Our ref: HA/2021/123109/01-L01
Your ref: LU/84/21/PL
Date: 28 April 2021

CHANGE OF USE OF PREMISES TO A MIXED USE COMPRISING OF 1 NO. 4-BEDROOM HMO UNIT & RETENTION OF 1 NO. BED-SIT UNIT AT FIRST FLOOR; 2 NO. HOLIDAY LET USE UNITS AT GROUND FLOOR WITH REDUCTION IN SIZE OF RETAINED HAIRDRESSERS & ANCILLARY RETAIL STORAGE SPACE & STAFF FACILITIES TO BE PROVIDED AT BASEMENT LEVEL

36 - 38 SURREY STREET LITTLEHAMPTON BN17 5BH

Drawing Name
Basement, GF and FF Plans - Proposed

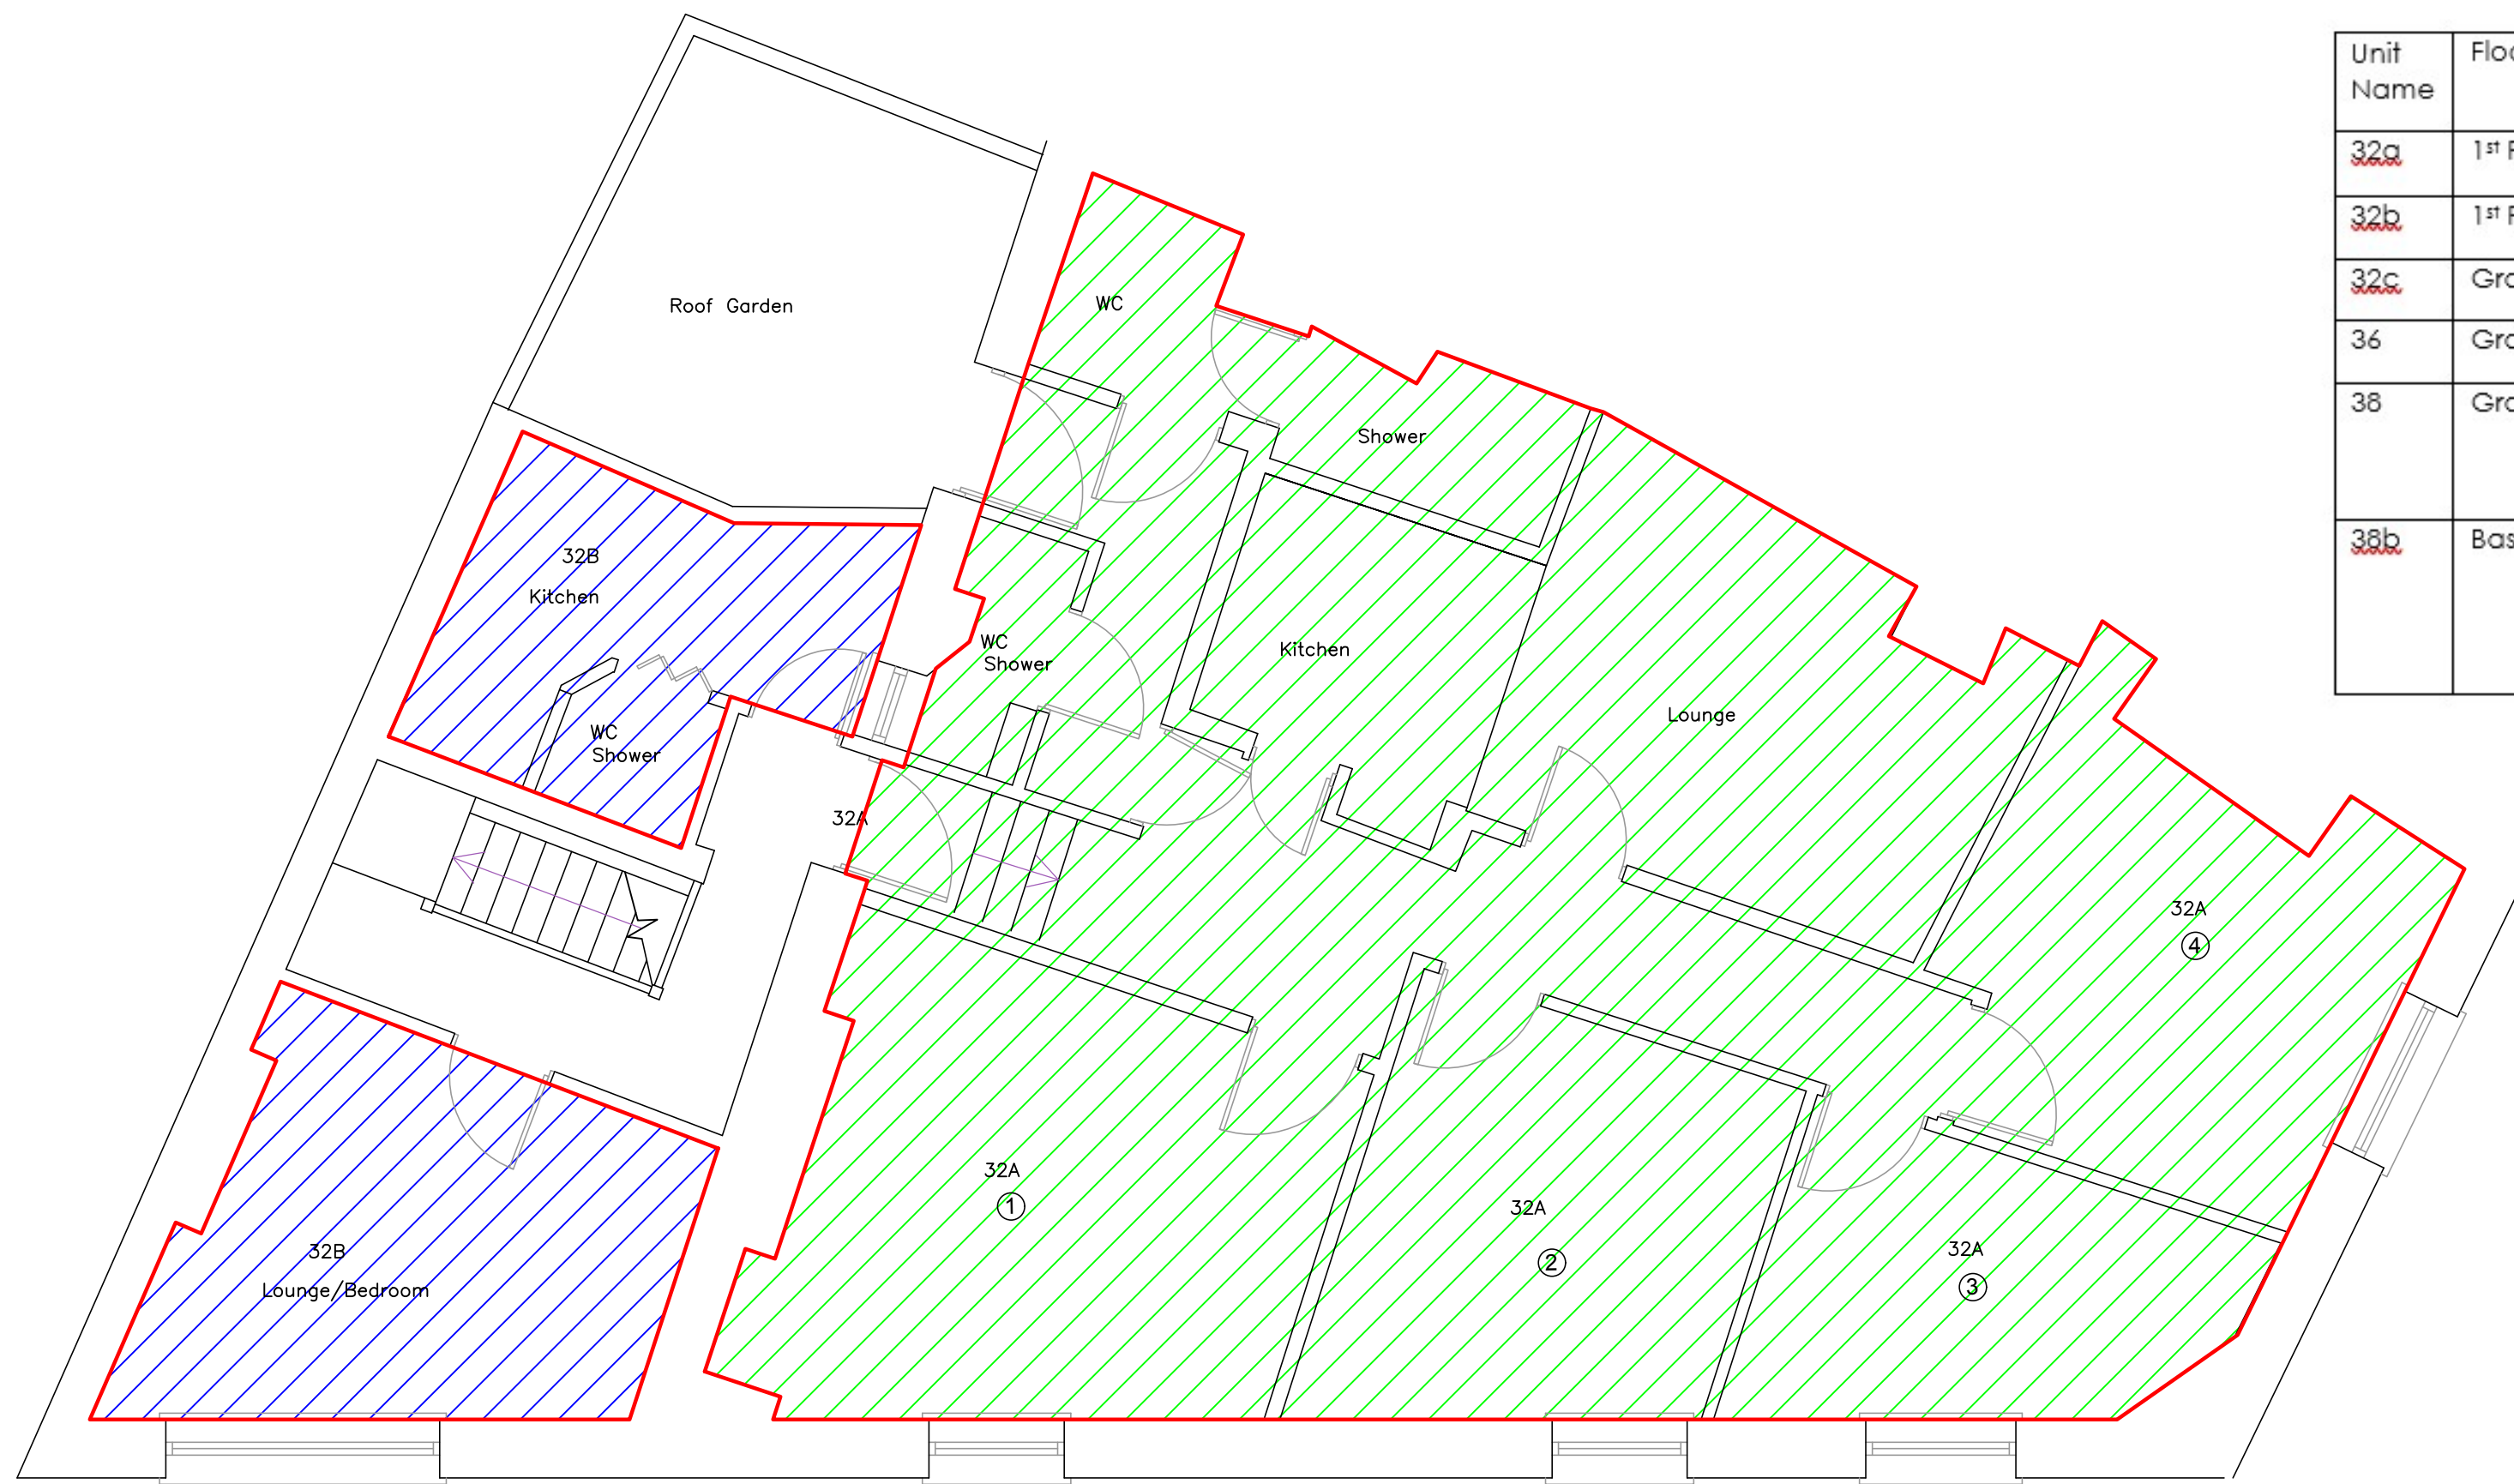
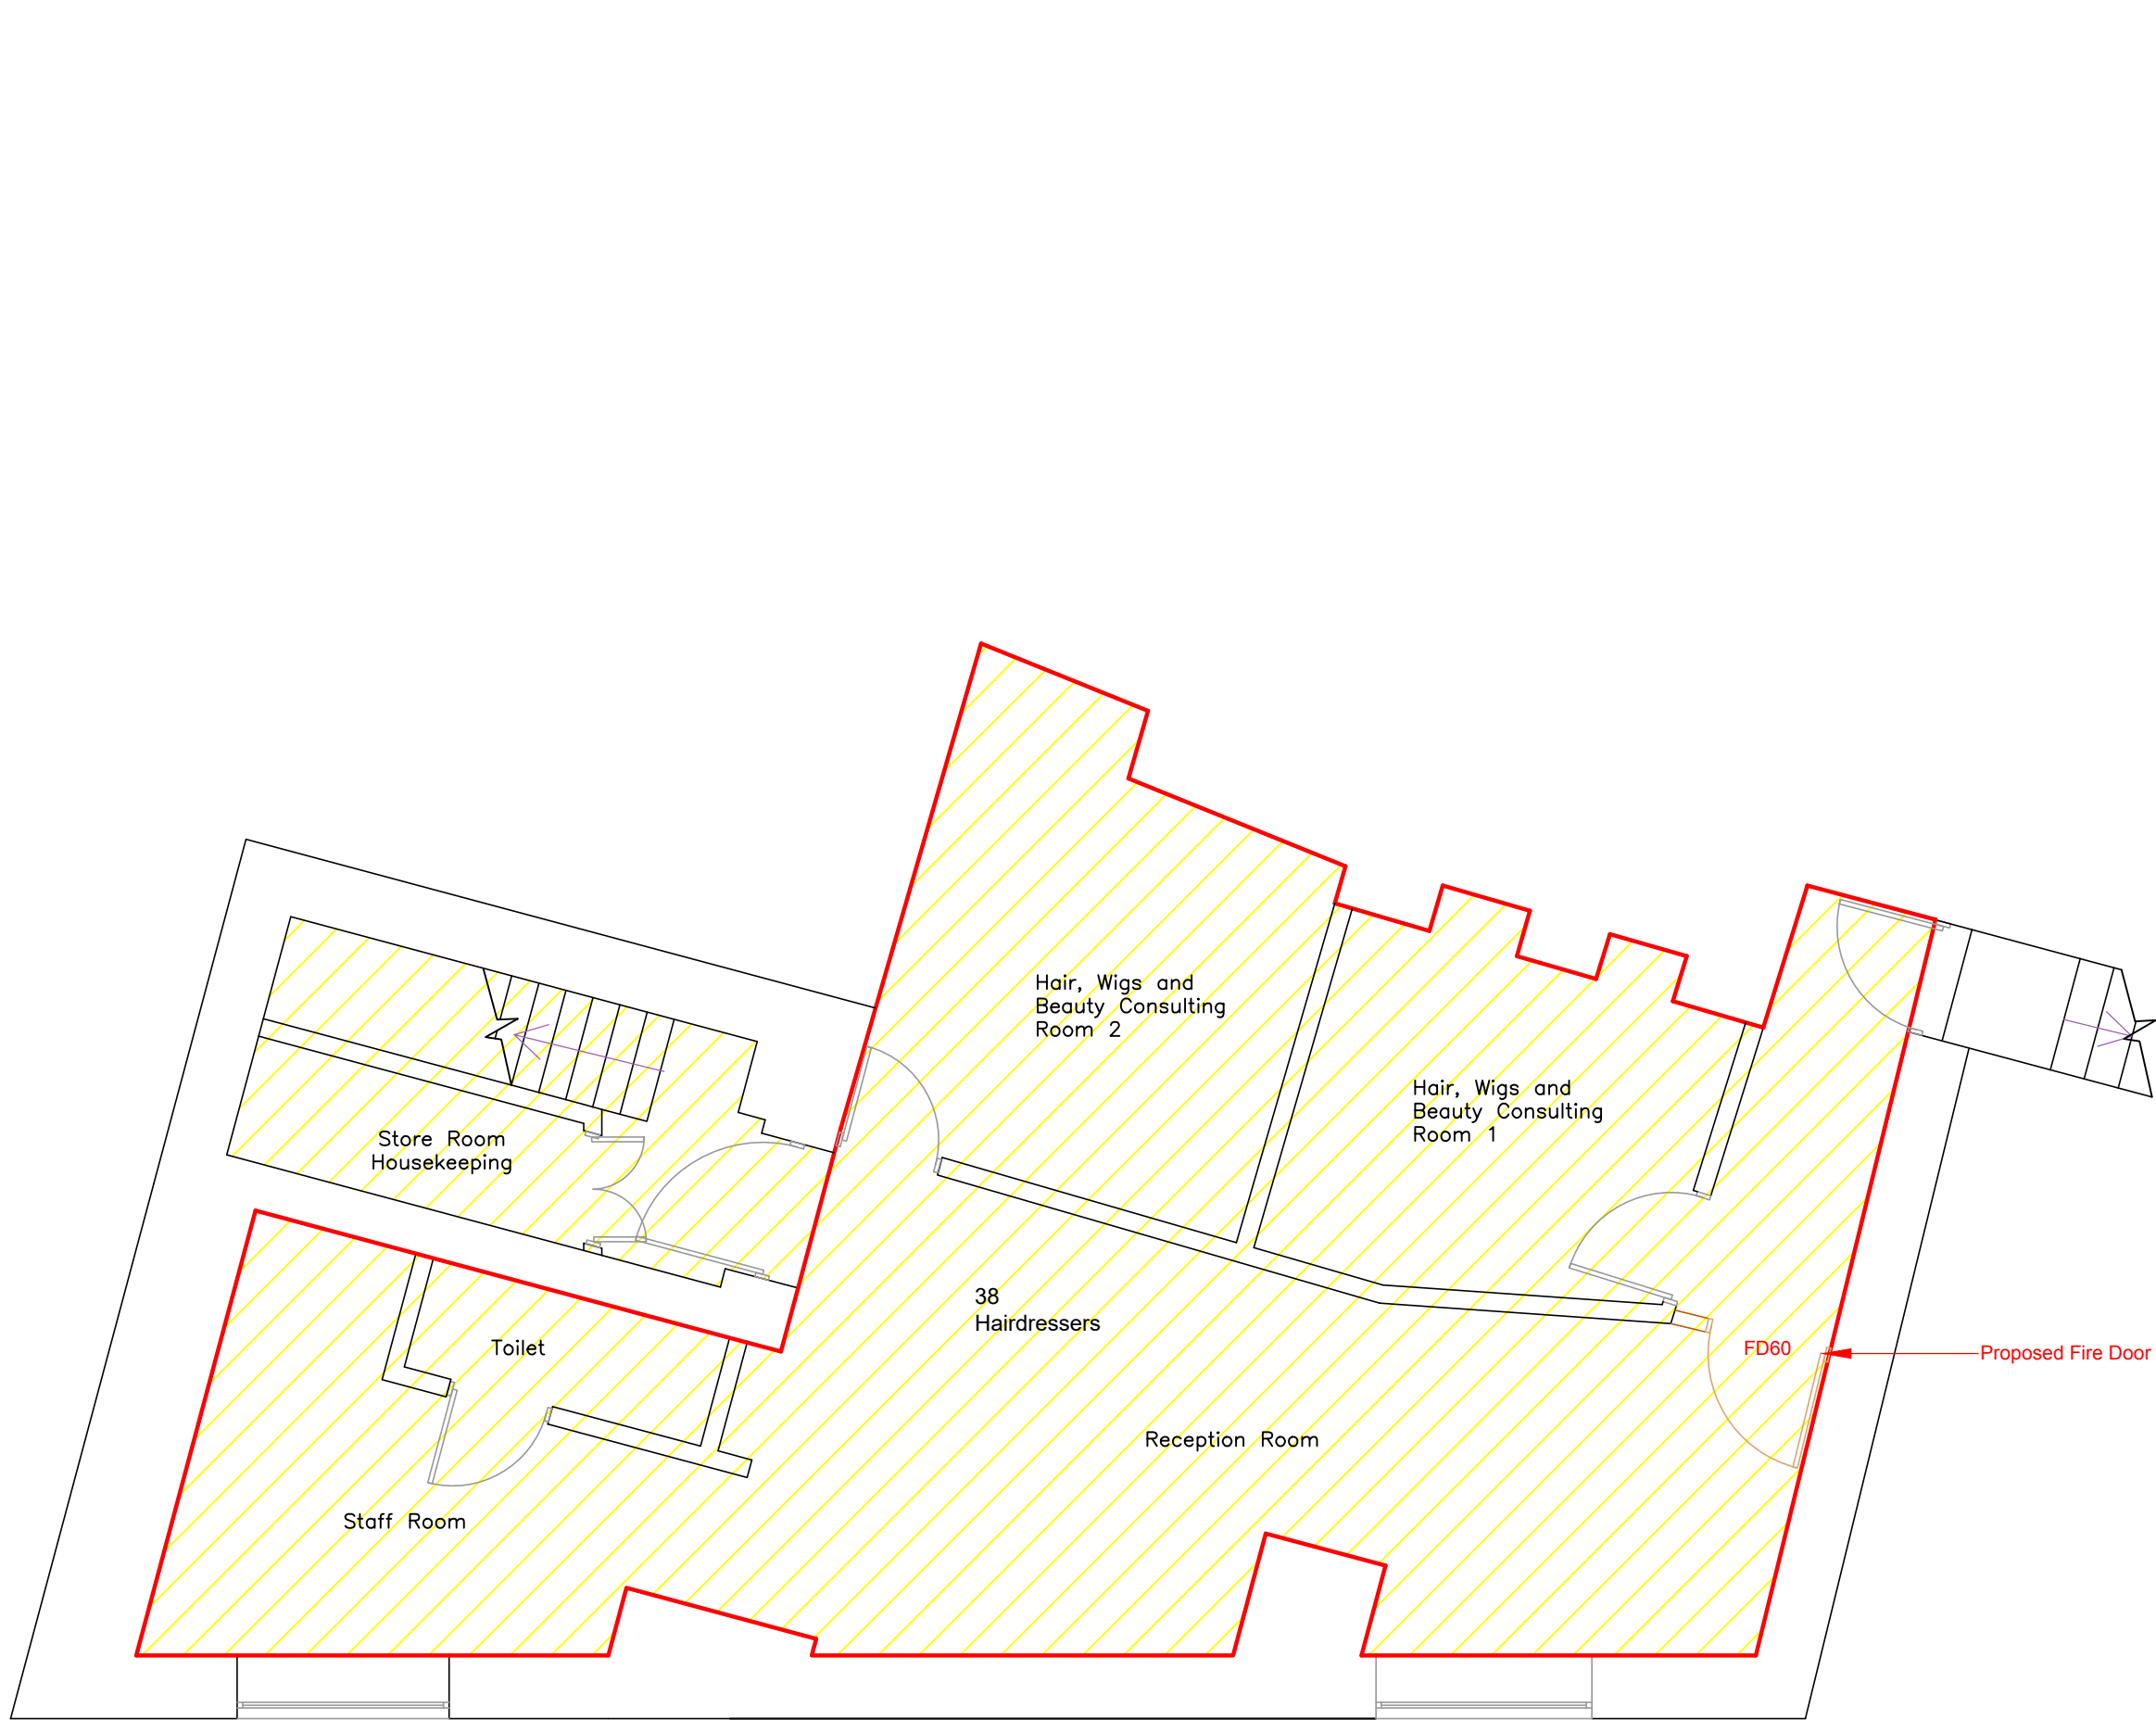
1. Nor residential or holiday let units may be placed in the basement.
2. Internal access from the ground floor holiday lets to the first floor must be maintained for use in an emergency
